Application No: FP/84/21/PL
Site Address: Land adjacent to The Gun Post Clyde Road Felpham PO22 7AH
Description of works: 1 No. additional self-contained beach hut with sleeping accommodation. This site is in CIL Zone 4 (Zero Rated) as other development.

Thank you for your internet representation made on 12th May 2021 which has been recorded as an objection with the comments as follows:

Street Scene

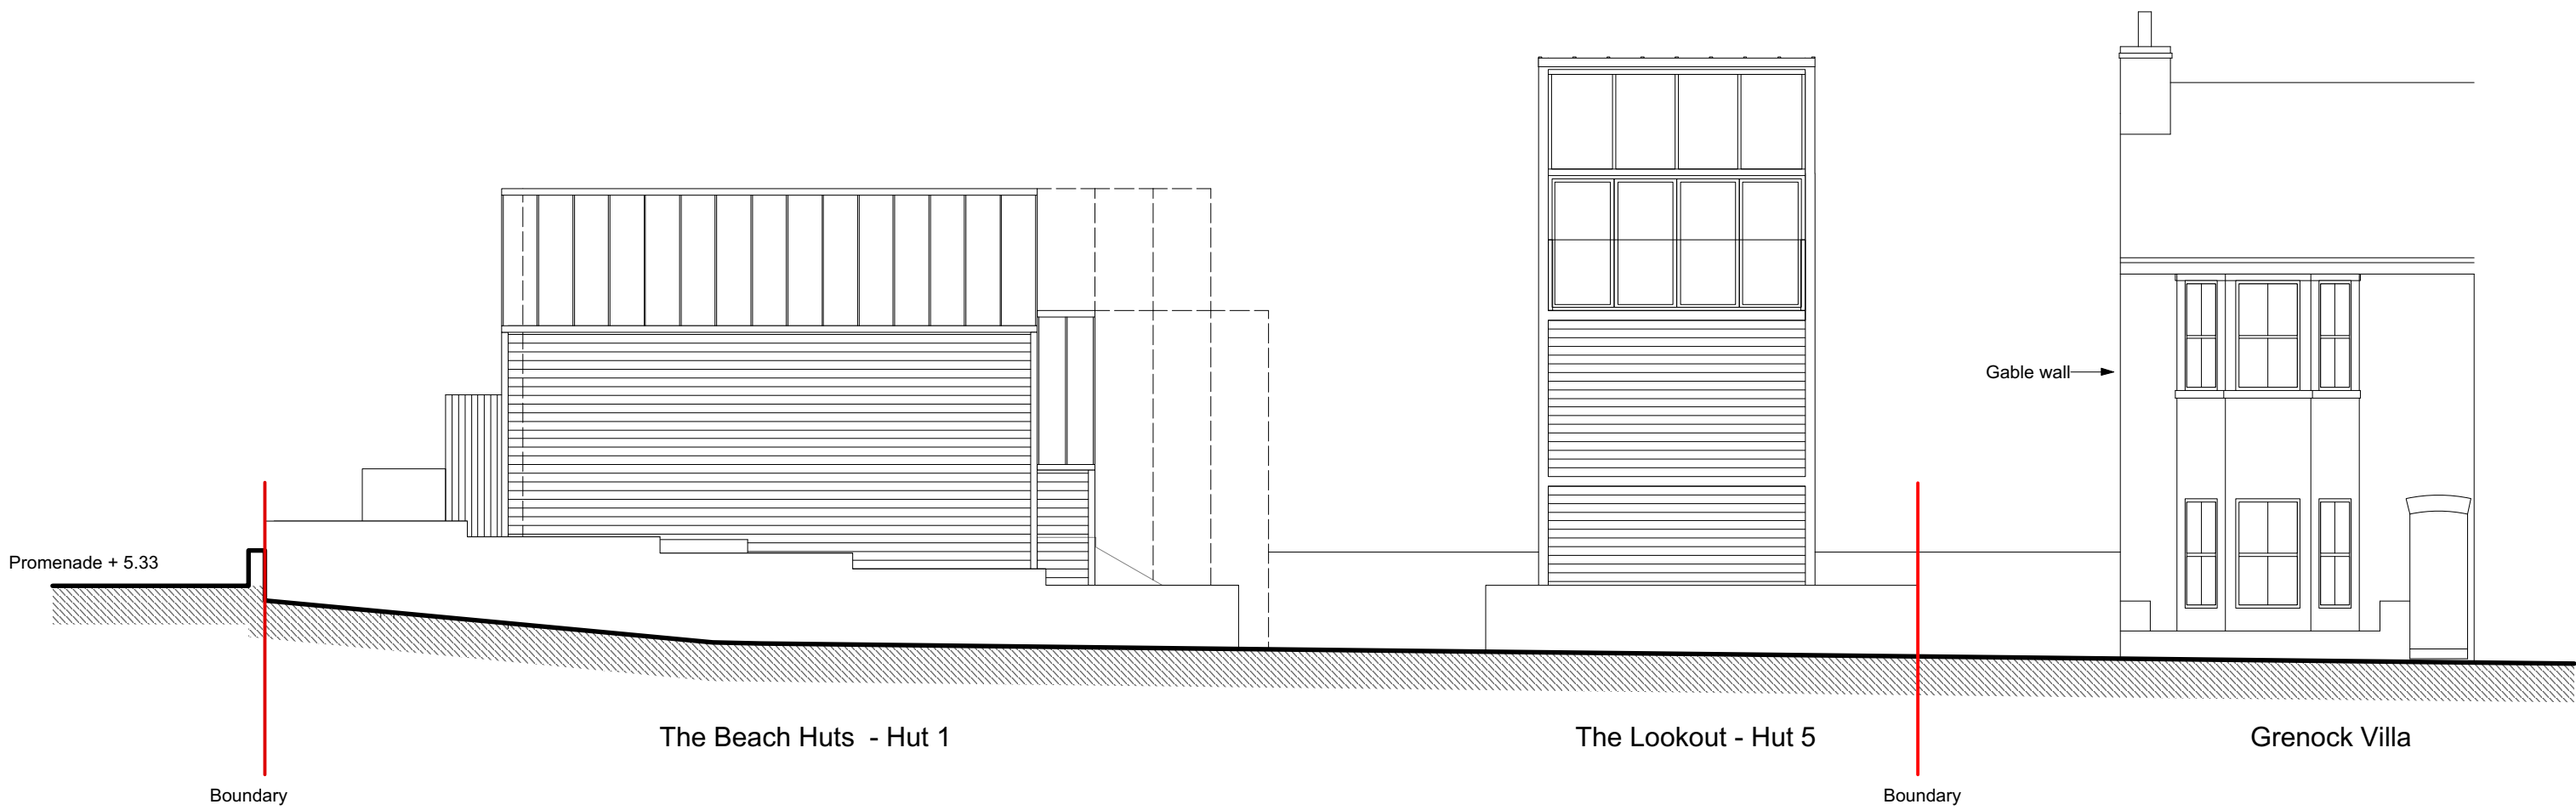
1. Mass. The new Beach Hut (fancifully called a hut) is about 3 storeys high (about 7.8 metres) and goes up to chimney height of the adjacent terraced house to the west (taking its light)

Proposed Site Plan
Scale 1 : 200

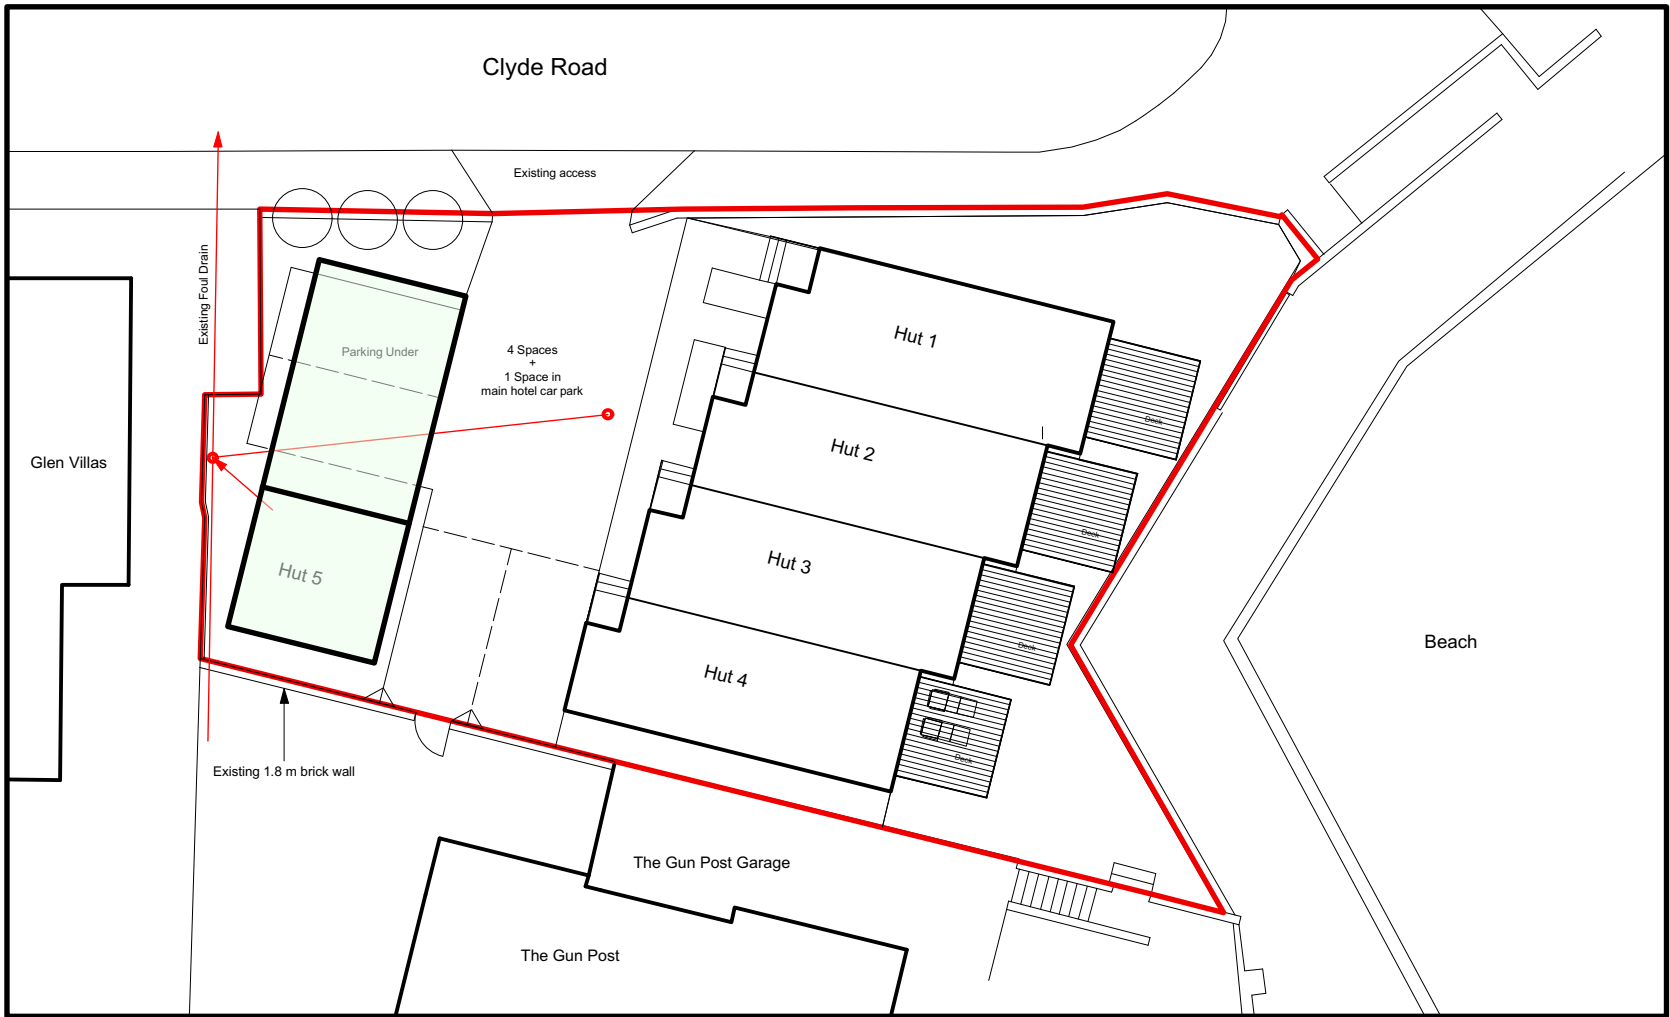
2. Overdevelopment. The Hut is to be very close to the edge of the site, and is visually intrusive to adjacent buildings.
3. Parking. The docs state that a car space for the new hut will be available in the main hotel car park. In season this is already too small, with visitor cars having to park in Clyde Road and Sea Road. In addition, the recently enlarged garden terrace attracts increased numbers of visitors (a good thing) but inevitably adds to the parking problems locally.

4. 2 replacement parking spaces are to be built under the new hut. Are they big enough to allow visitor cars (including SUVs which are likely to be the type of cars used by the families who will use the hut) to manoeuvre out of the spaces? They will need at least their length again to turn out.

South Elevation

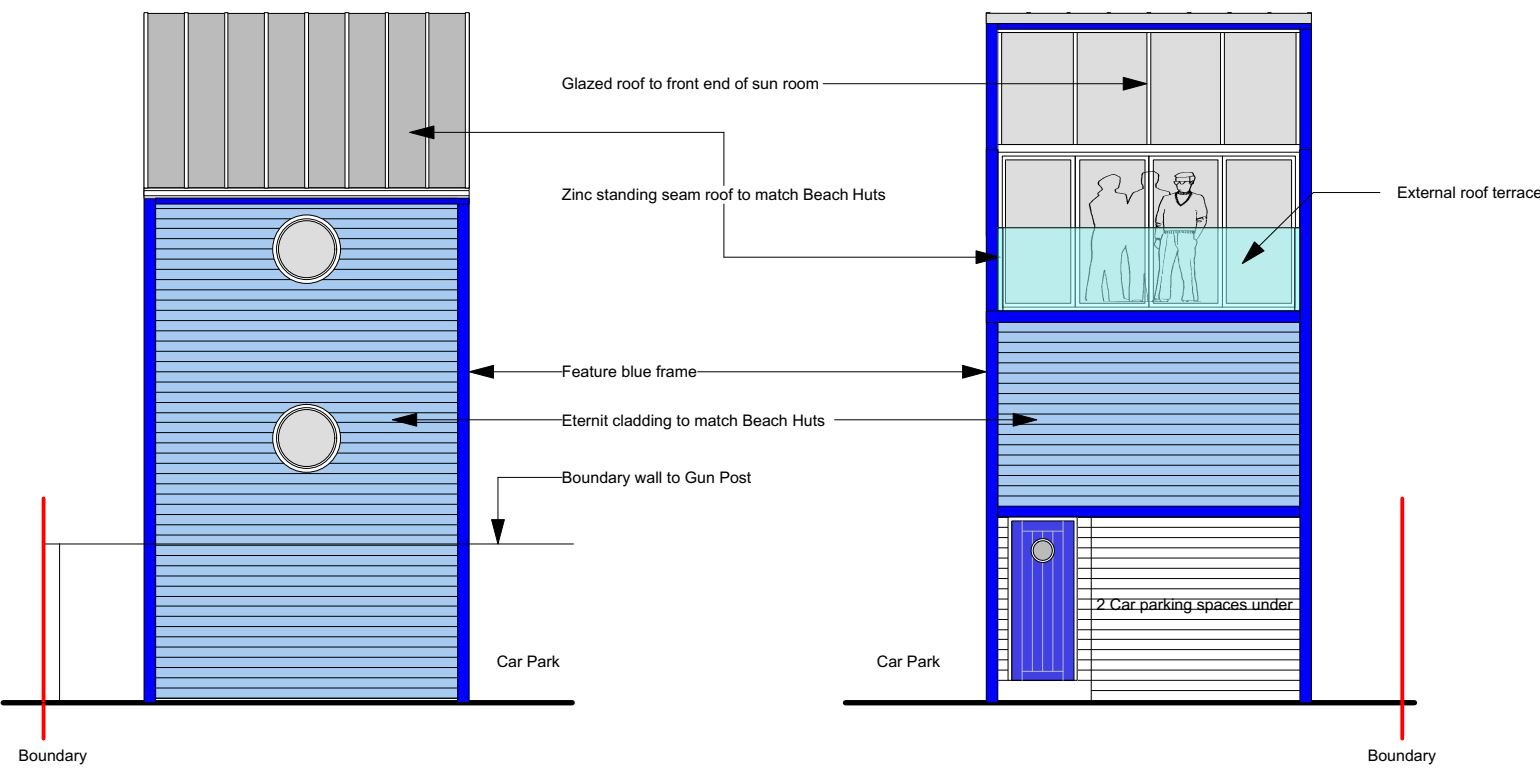
5. The porthole windows on the South elevation of the 3 storey hut would need to be opaque glazed as they would overlook the back of Outram House where the bedrooms are.
